Project #: 1009245 Application #: 12DRB-70221
Project Name: North Albuquerque Acres Unit 3
Agent: Rick Bennett Architects Phone #:

**City of Albuquerque
Planning Department
Inter-Office Memorandum**

DEVELOPMENT REVIEW BOARD – SPEED MEMO

DRB CASE NO: 1009245

**CONCEPTUAL GRADING AND DRAINAGE PLAN  
GUARDIAN SELF STORAGE**

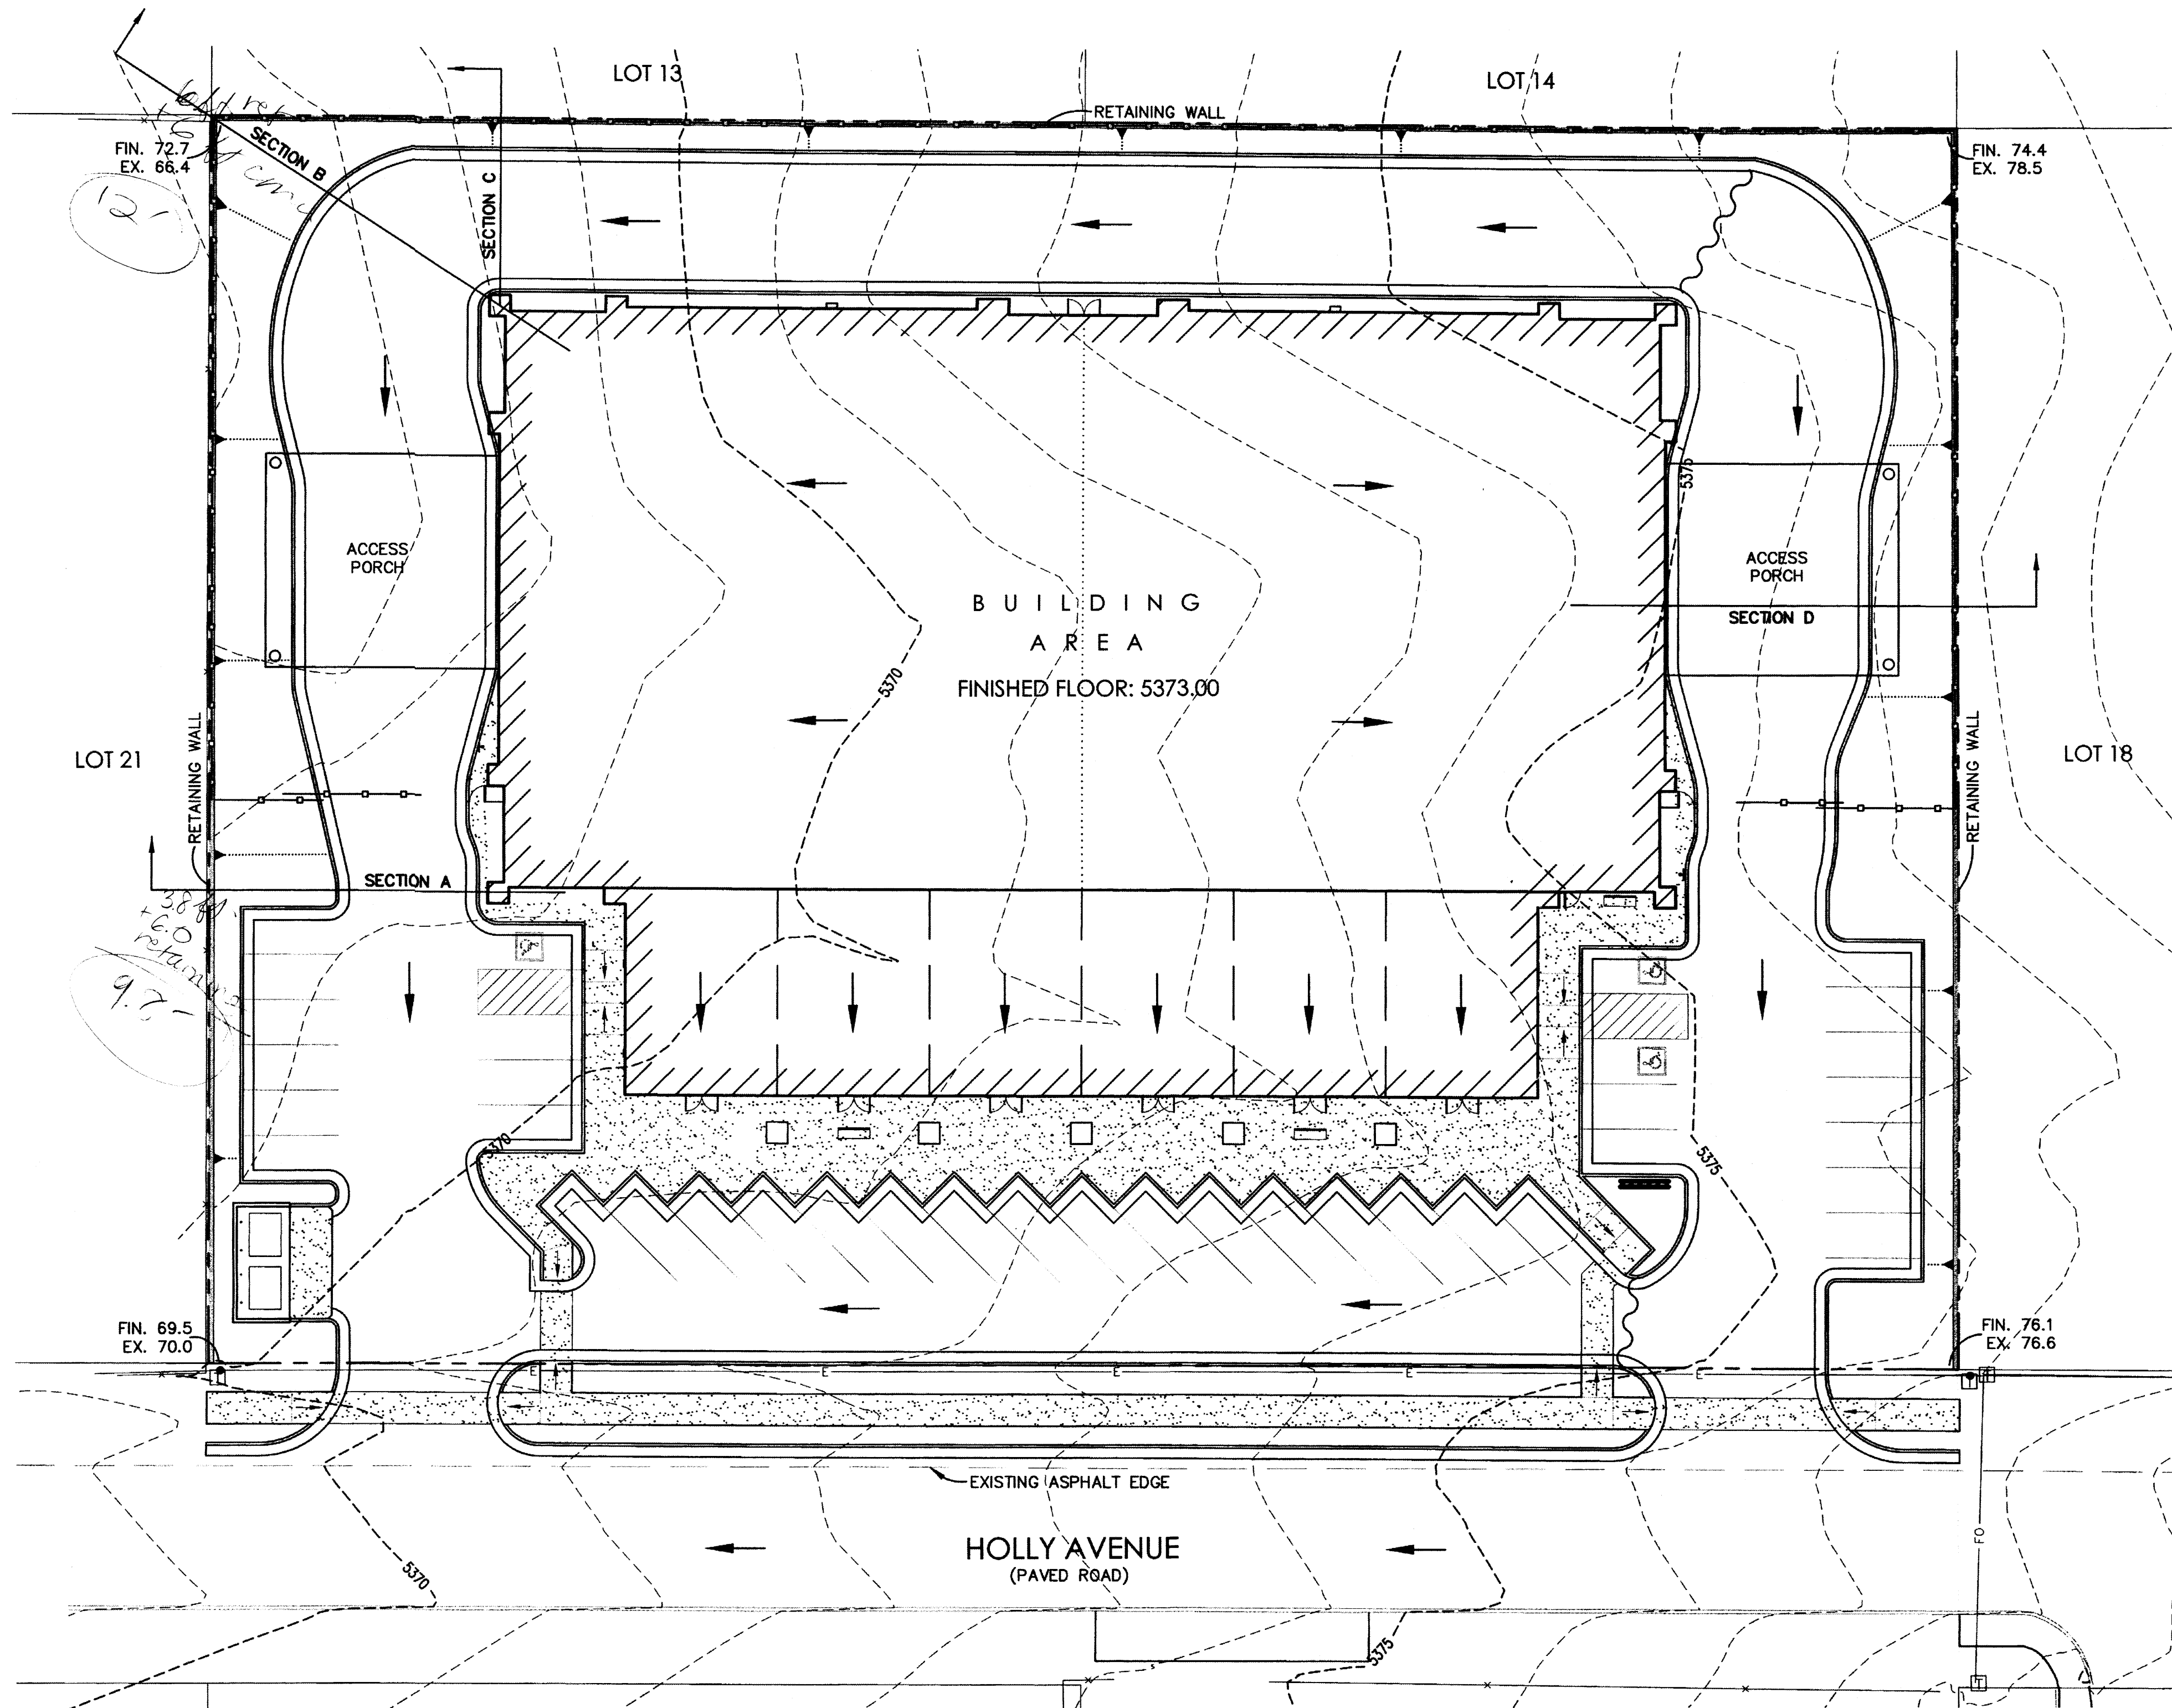
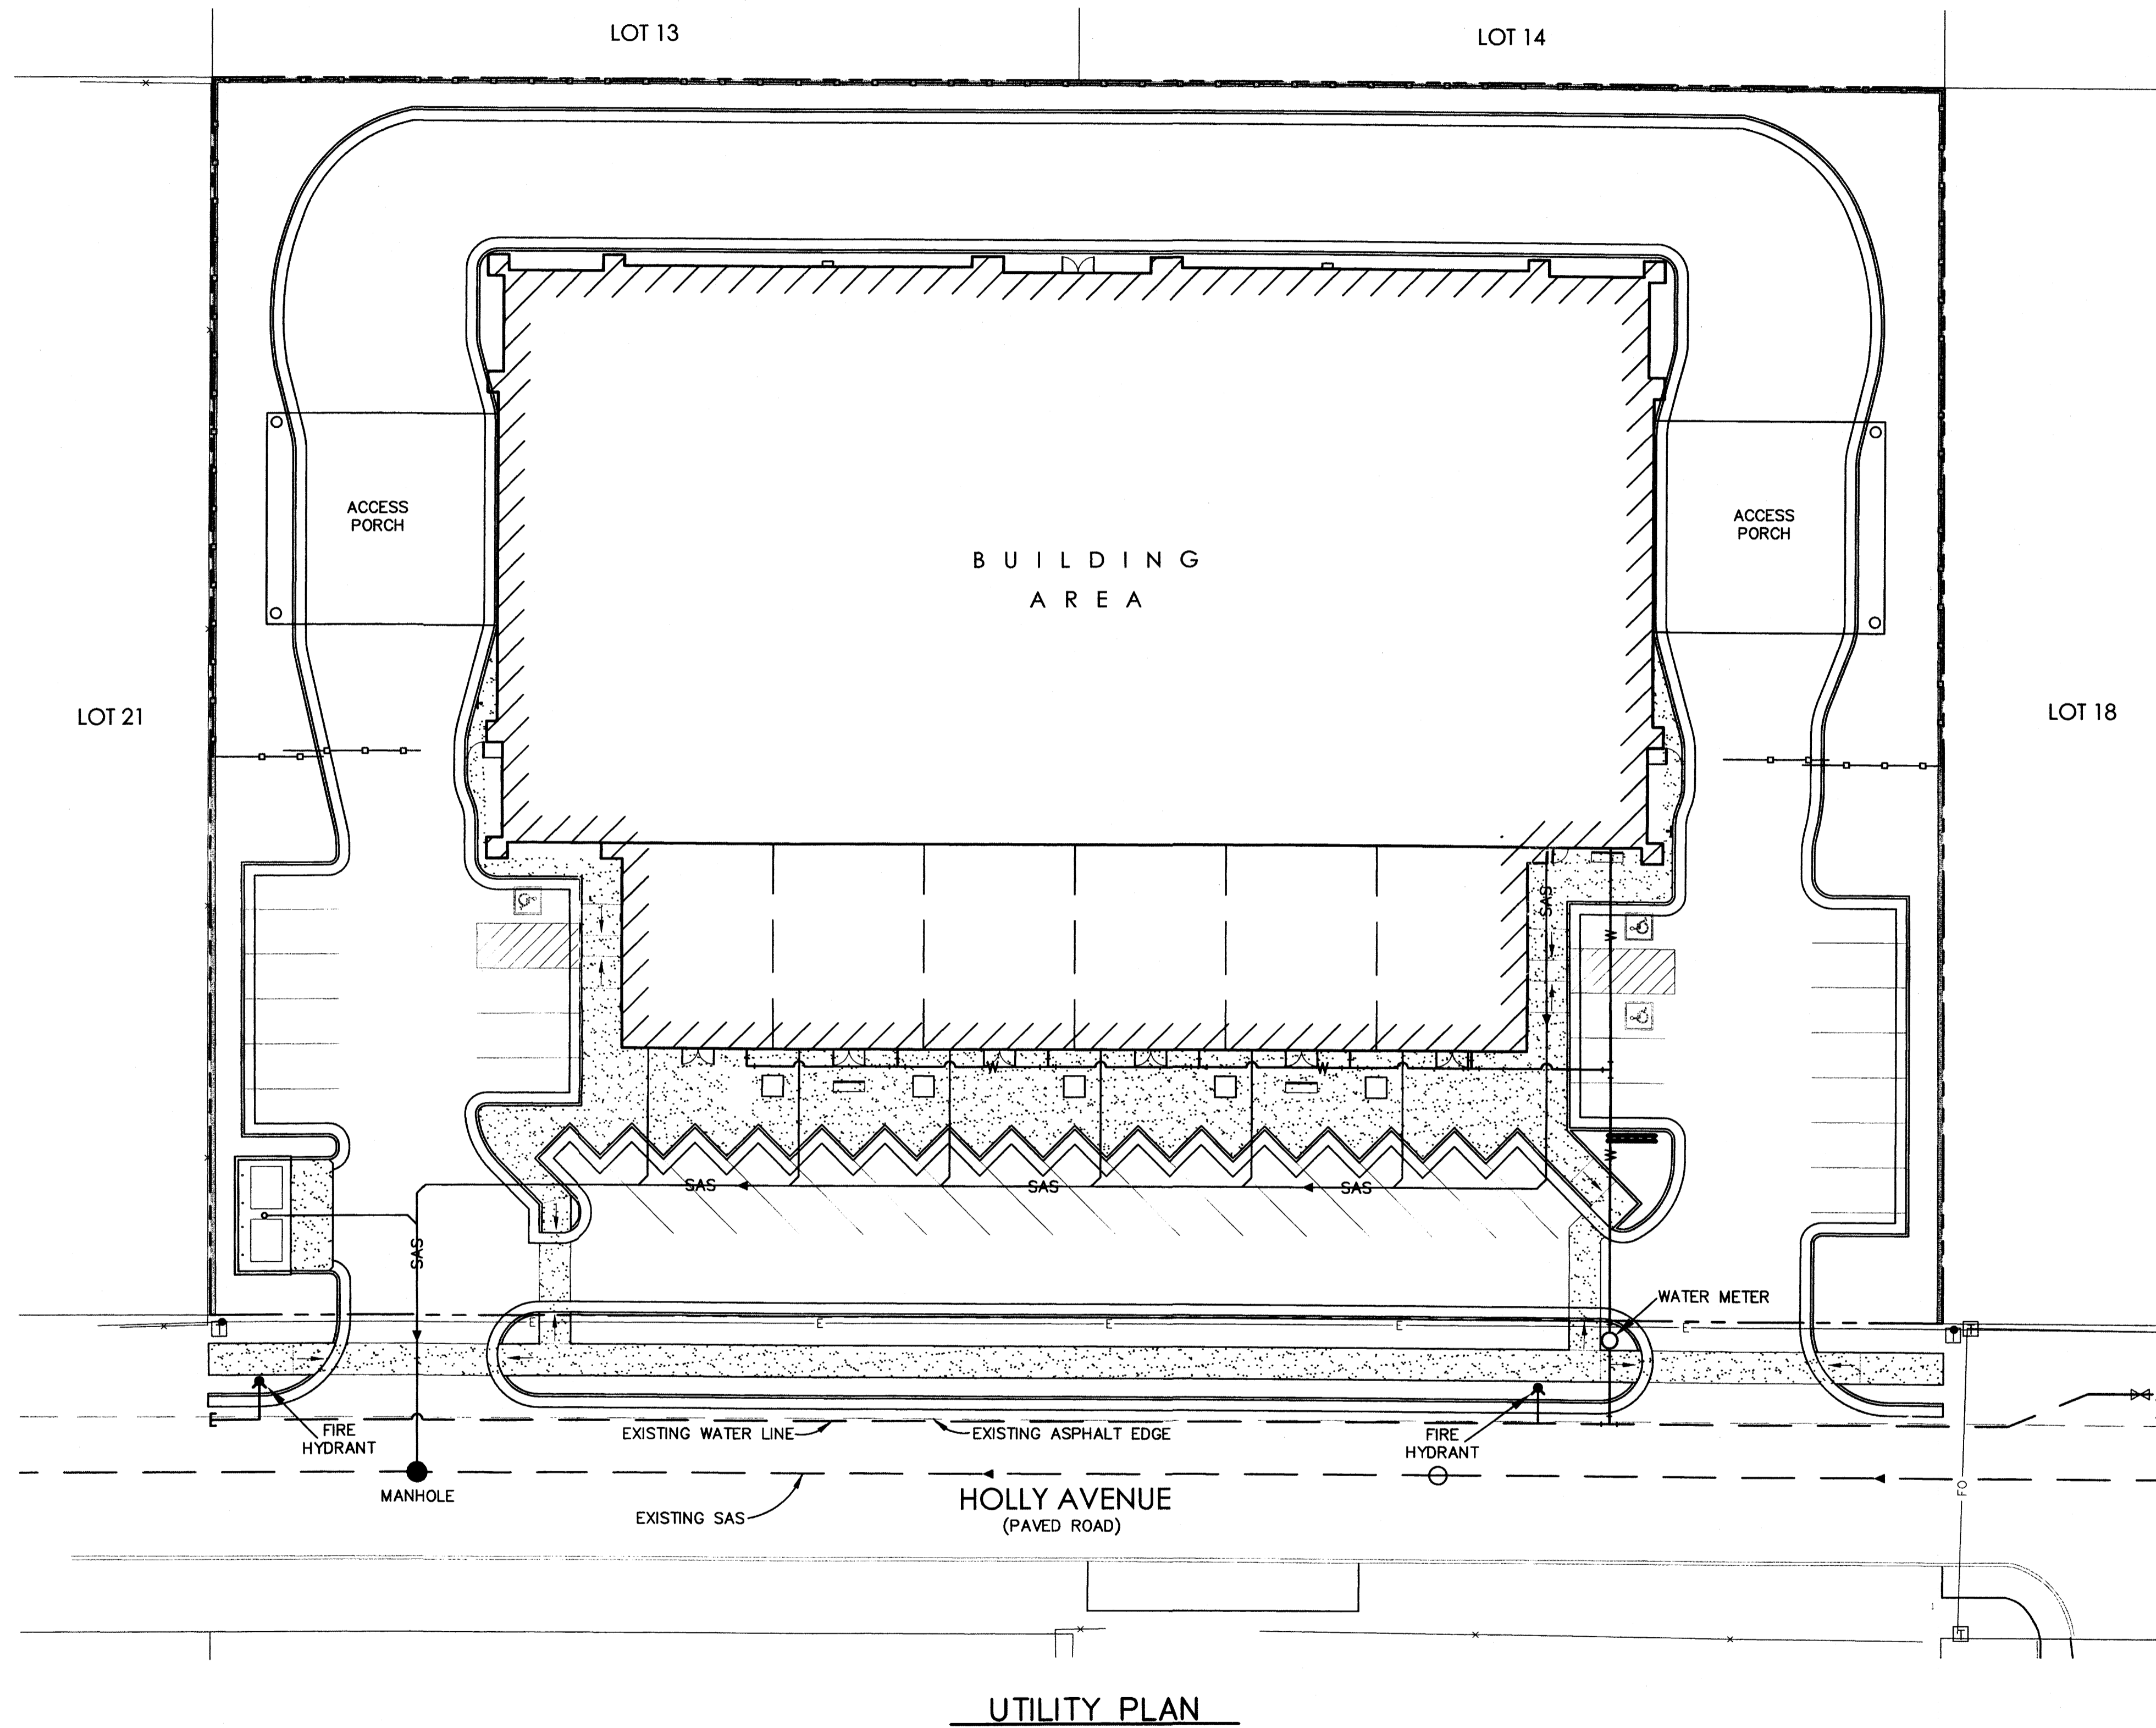
Hydrology has not received the revised Conceptual Grading and Drainage plan.
